Dakota Springs Engineering

Date: March 11, 2018

Subject: Springs at Waterview Preliminary Plan
SP-16-005

This memorandum has been prepared to address the comments you provided concerning the Springs at Waterview Final Plat in your letter dated November 27, 2017 (Received March 6, 2018-the same comments as your November 27, 2018 letter). Your comments are provided below with our response comment immediately following in *italics*.

PROJECT SPRINGS AT WATERVIEW
 SHEET TITLE SITE PLAN
 FROM _____ TO _____
 JOB NO. 021601 SHEET 2 OF 3

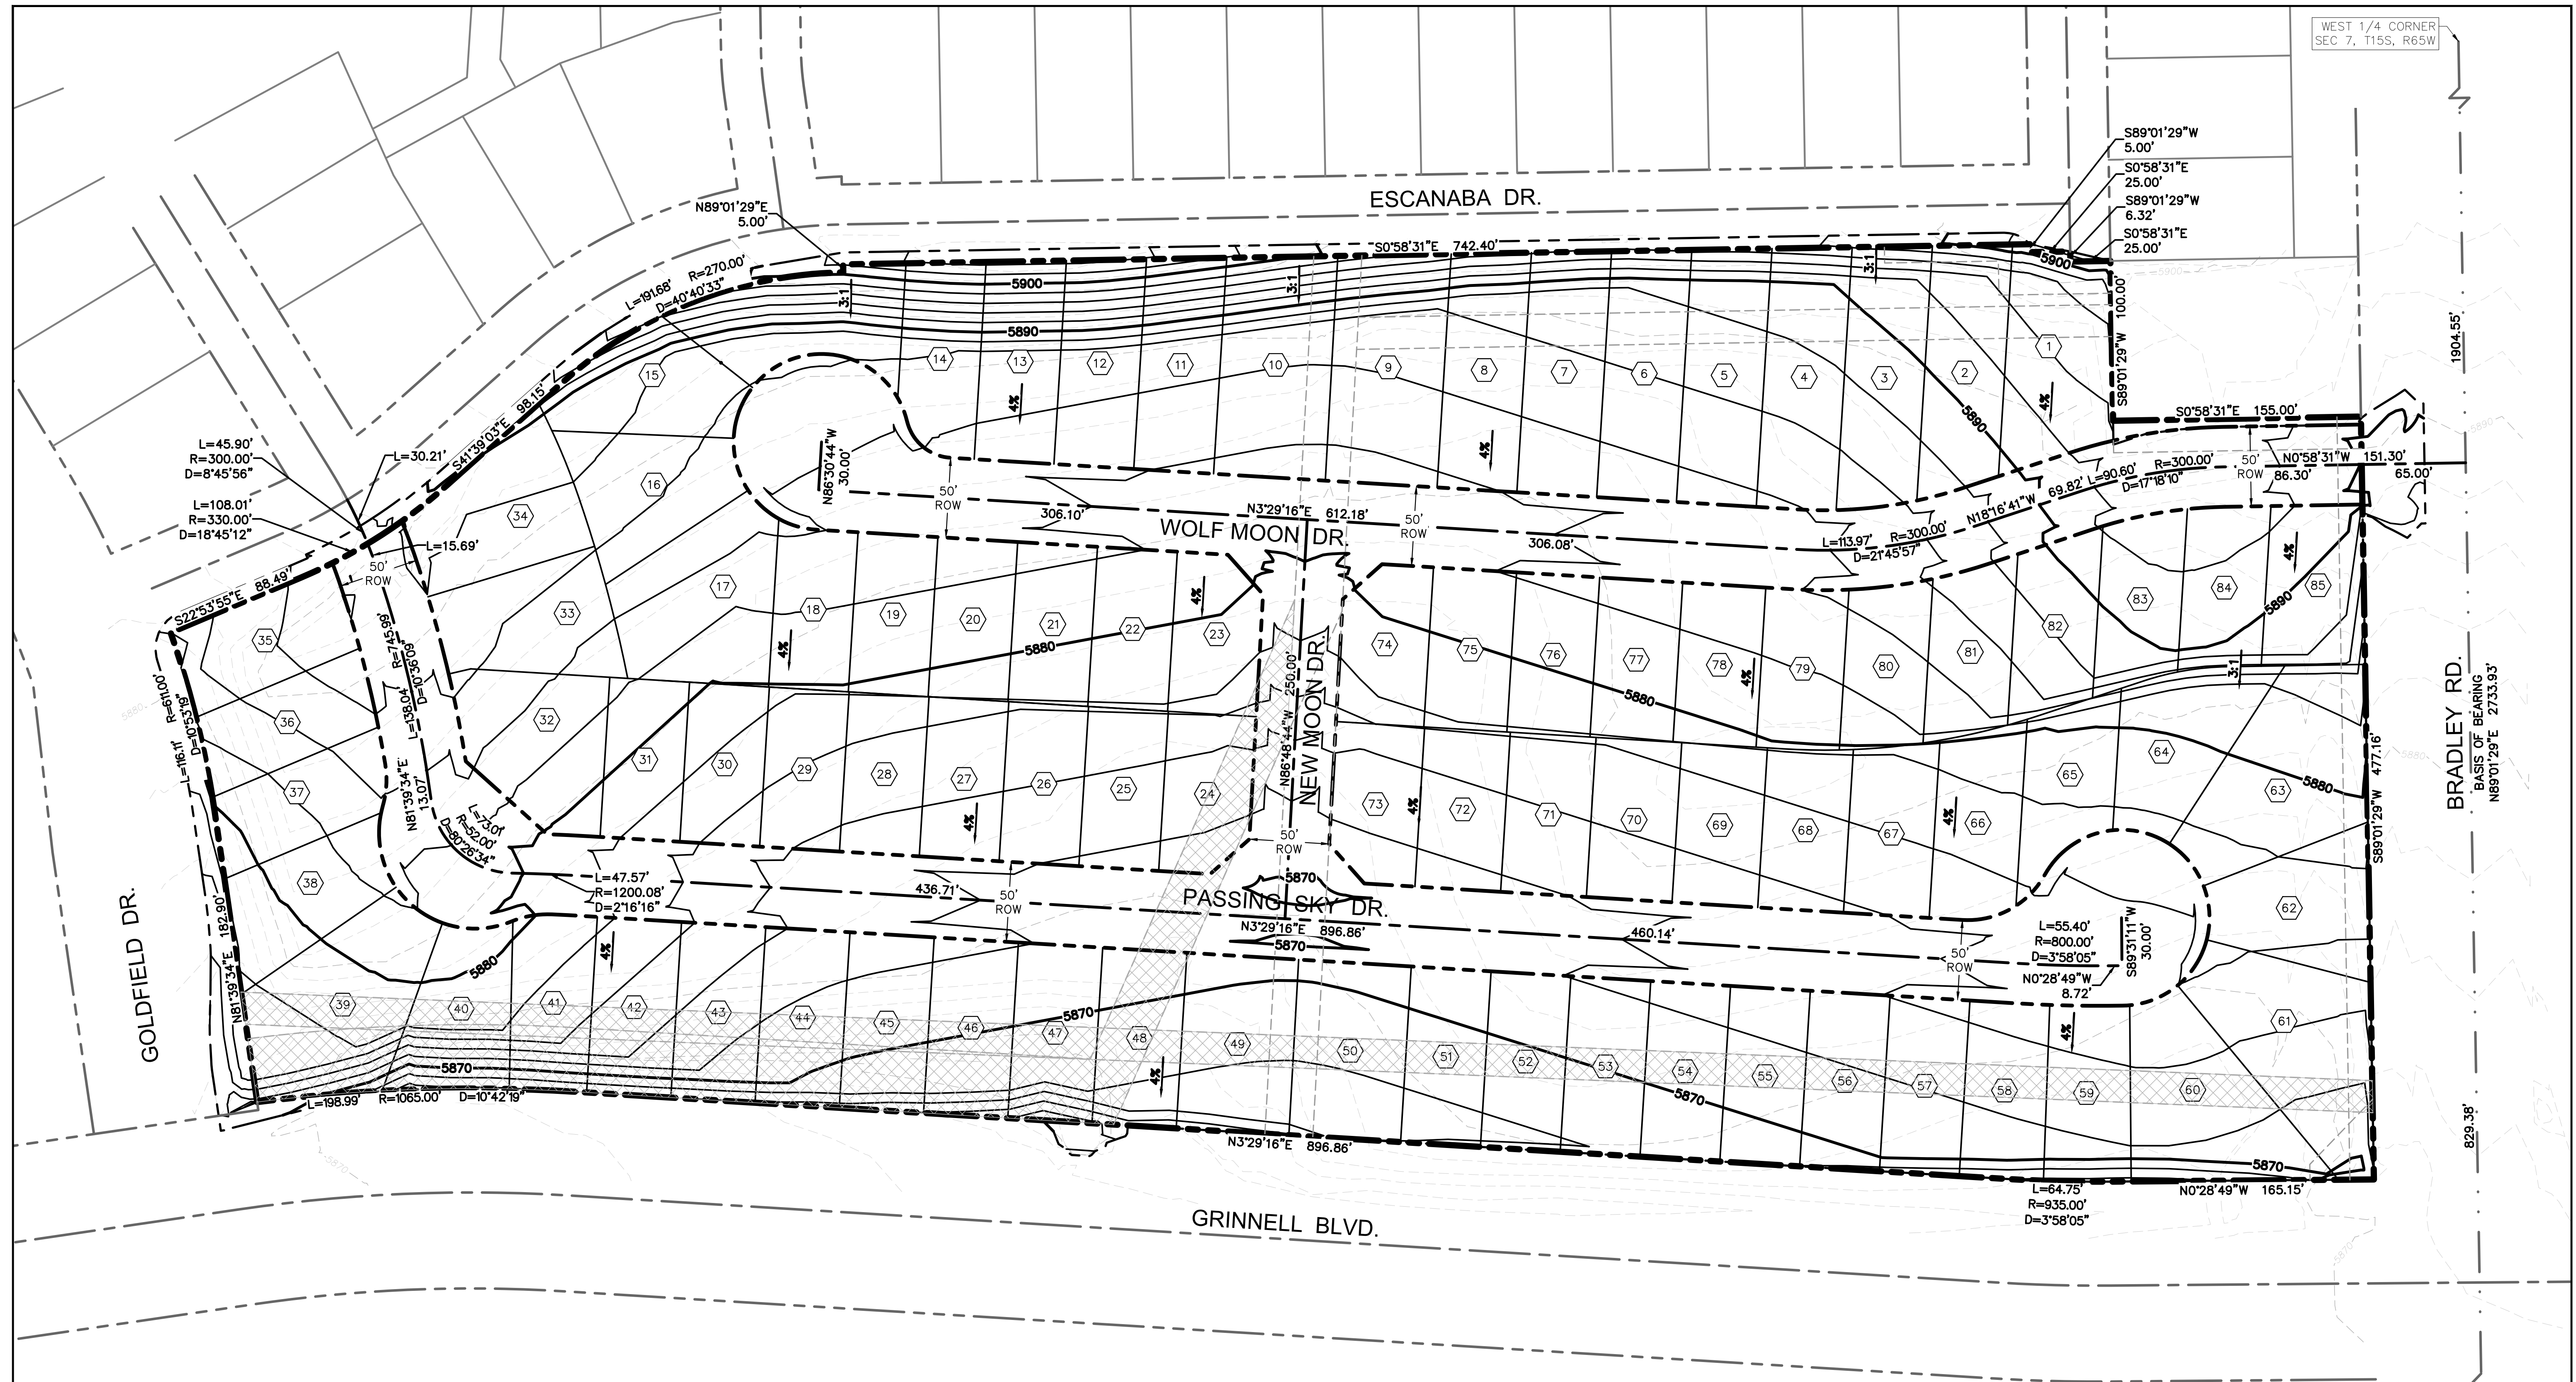
Regarding the existing 20' utility easement, the correct page number is 242. Also, remove the reception number - the easement was not granted by the previous plat. Item has not been addressed.

Modified

Change the street name from Grinnell Rd. to Grinnell Blvd. Item has not been addressed.

Addressed

PDF: 0102-1 - EARLY GRADING.PDF

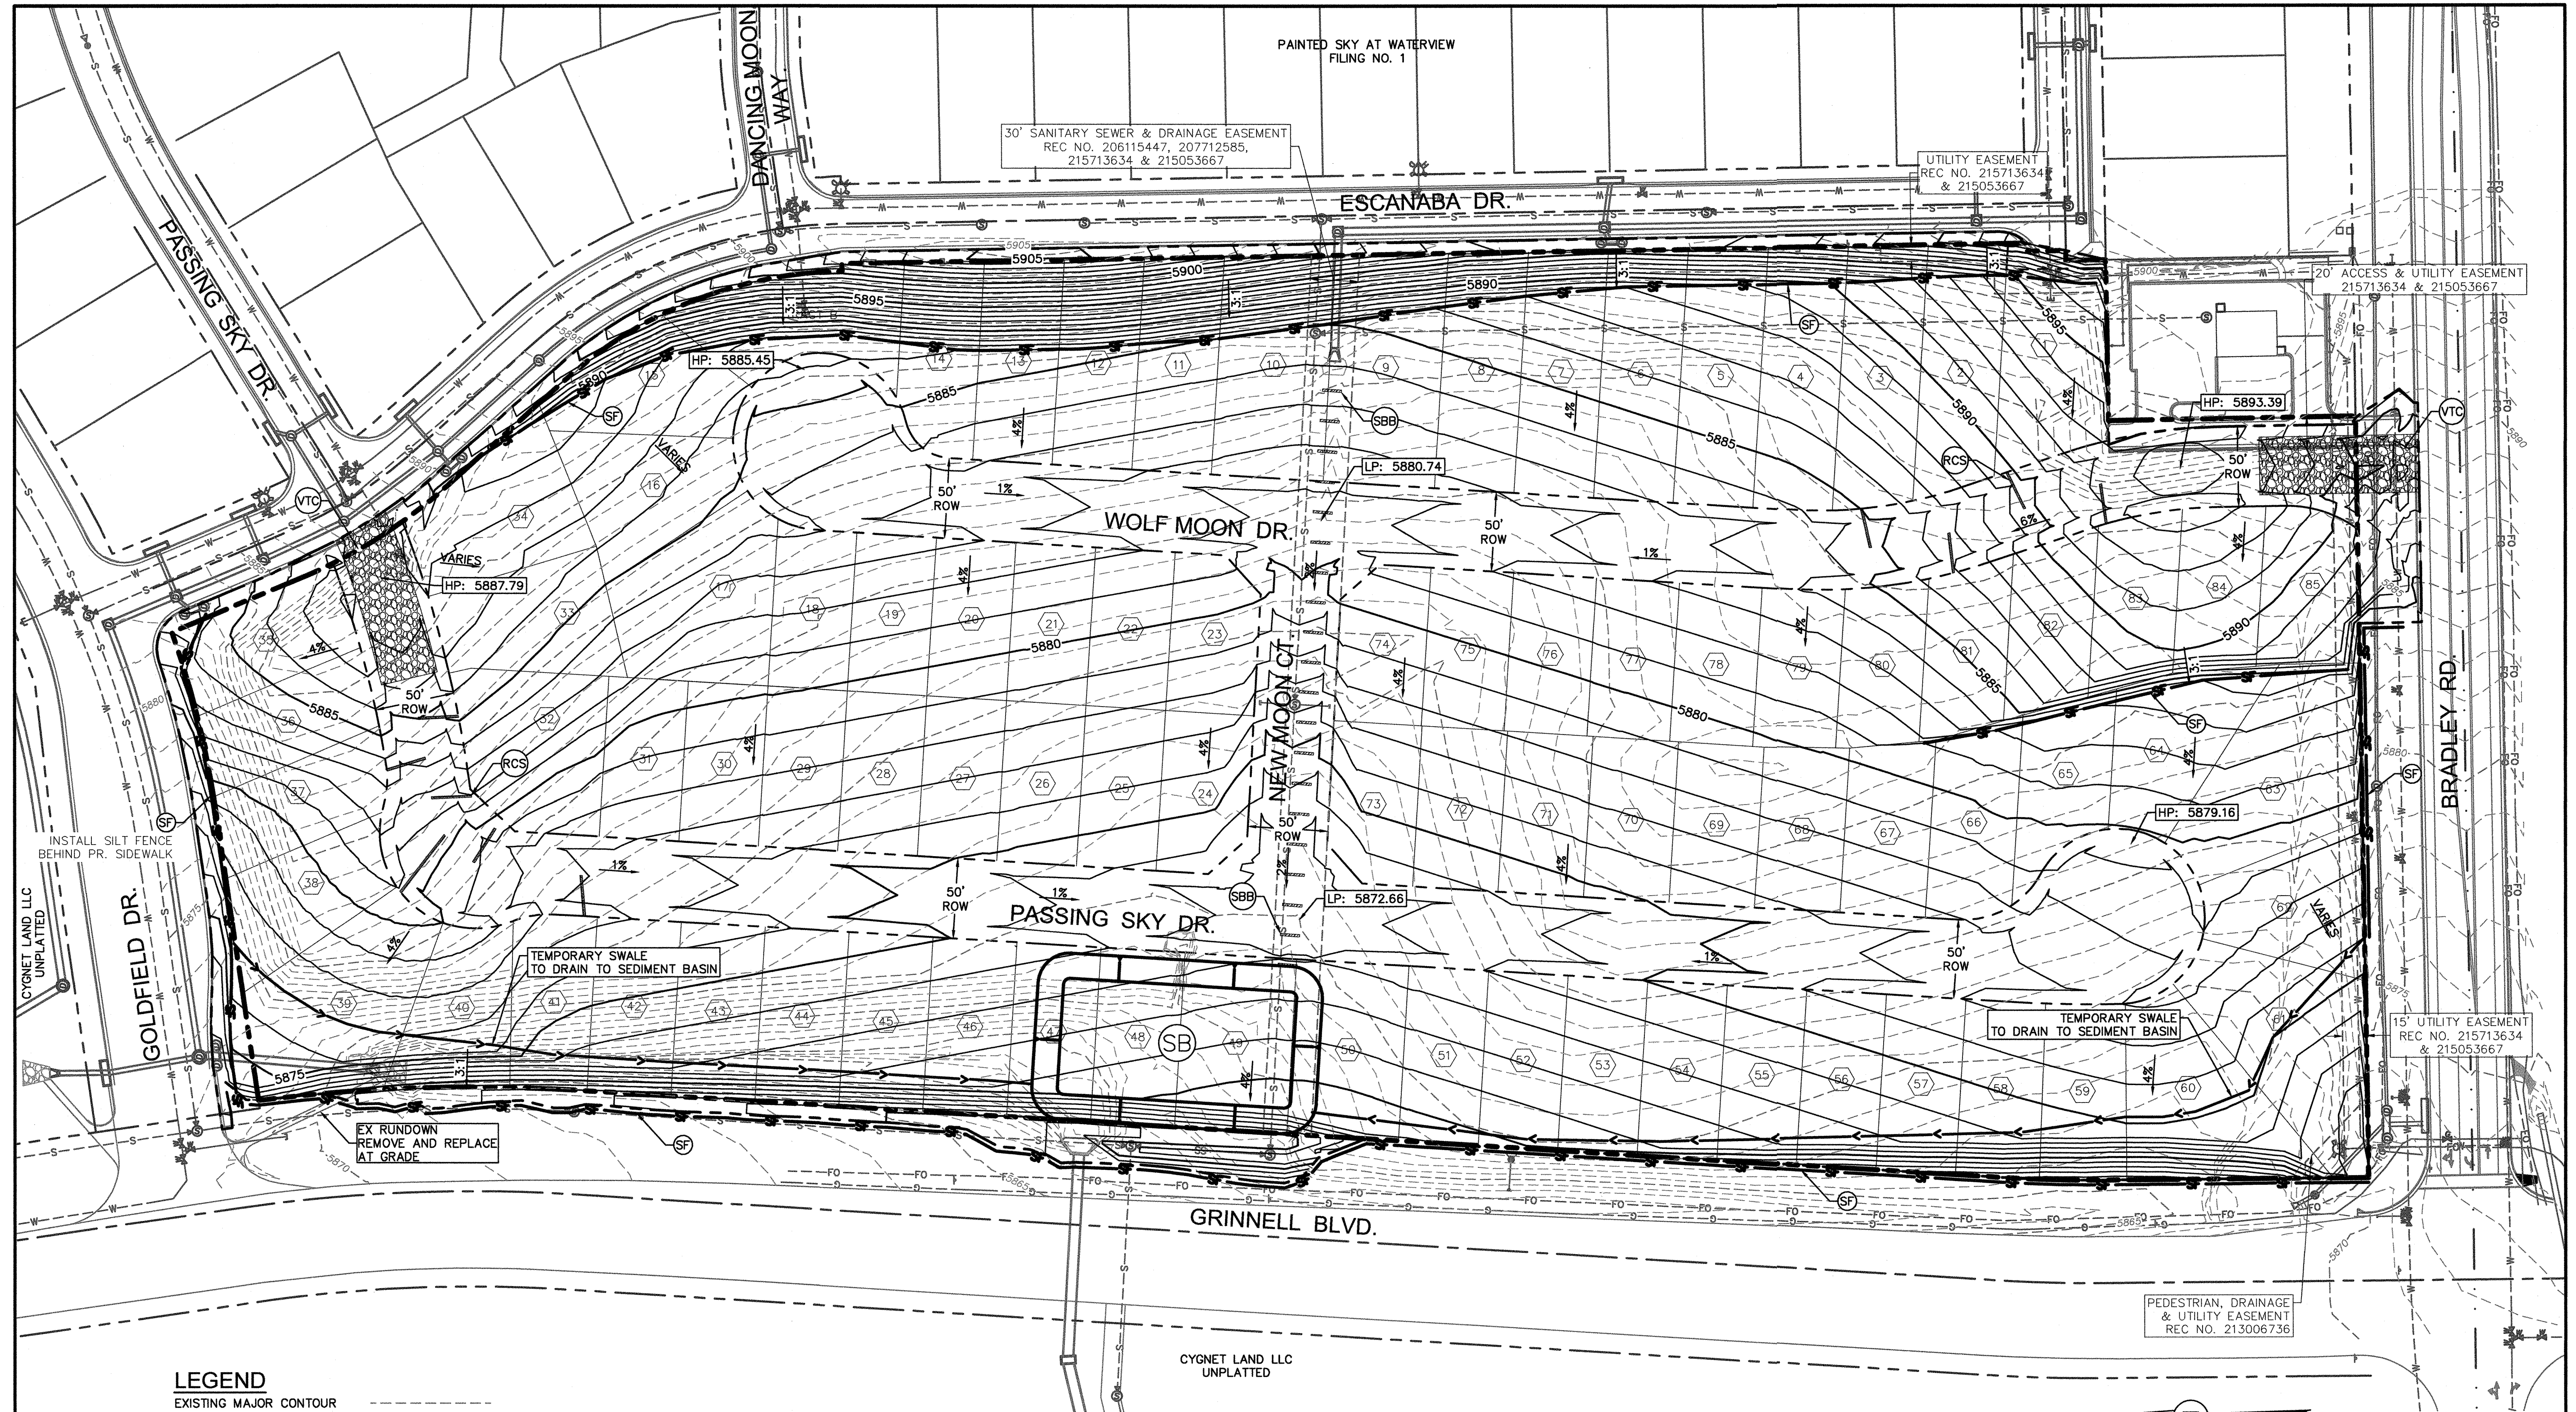
Review 2 Comments resolved on the following documents: - Letter of Intent Redline comments on the following documents will be uploaded by the Project Manager: - Preliminary Site Plan Per the email correspondence on Feb 20, 2018, an early grading permit is being request. Therefore, submit the following documents with the preliminary plan application: - Financial Assurance Estimate (Section 1 only) - ESQCP - SWMP - Pre-Development Site Grading Acknowledgement and Right of Access Form (attached) - Standalone Early Grading and Erosion Control Plan set (w/ Cover Sheet). Early grading is for dirt work only, therefore the GEC will not show proposed road C&G's or proposed storm drains & inlets. Temporary sediment basins will be required on-site. The PDR/FDR will need to be updated to include a section regarding early grading to include an exhibit delineating the tributary area for each proposed temporary sediment basin along with the associated sizing calculation.

These Items have been addressed with additional documents added to this submittal
OPTIONAL: ESQPC Applicant: ESQPC Required for Early Grading
